PLANNING AND INFRASTRUCTURE

16 June 2025

Re: State Significant Development Application Number SSD-74670720
38-42 Anderson Street, 3 McIntosh Street and 2 Day Street, Chatswood

FIGURE 15
WORKS REQUIRED TO SUPPORT HRV ACCESS

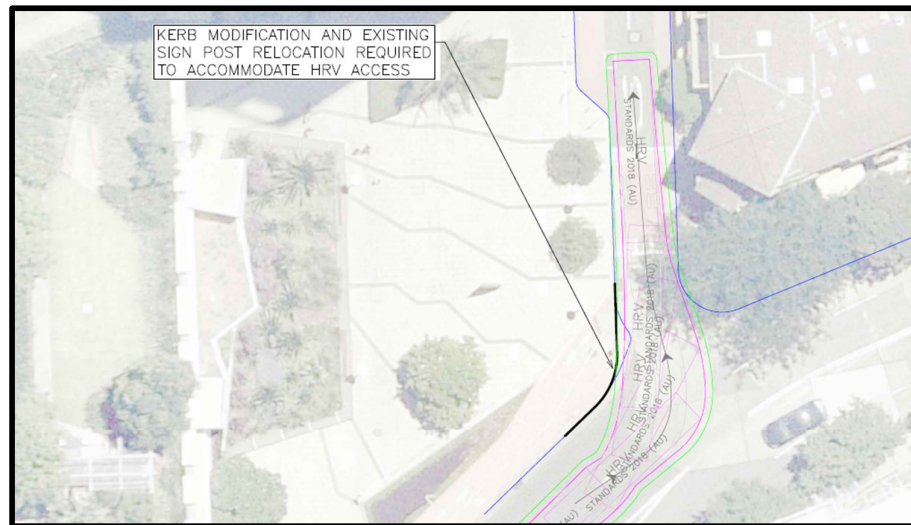
Council supports the provision of an on-site loading dock and access for Heavy Rigid Vehicles (HRVs) to facilitate waste collection and servicing. However, the proposed development has not adequately demonstrated that HRVs can access the basement in accordance with relevant design standards and Council requirements. Additional information is required, including detailed swept path diagrams and grade levels, to confirm that vehicles can enter and exit the basement in a forward direction. This is necessary to ensure safe vehicle manoeuvring and to maintain pedestrian safety within and around the site.
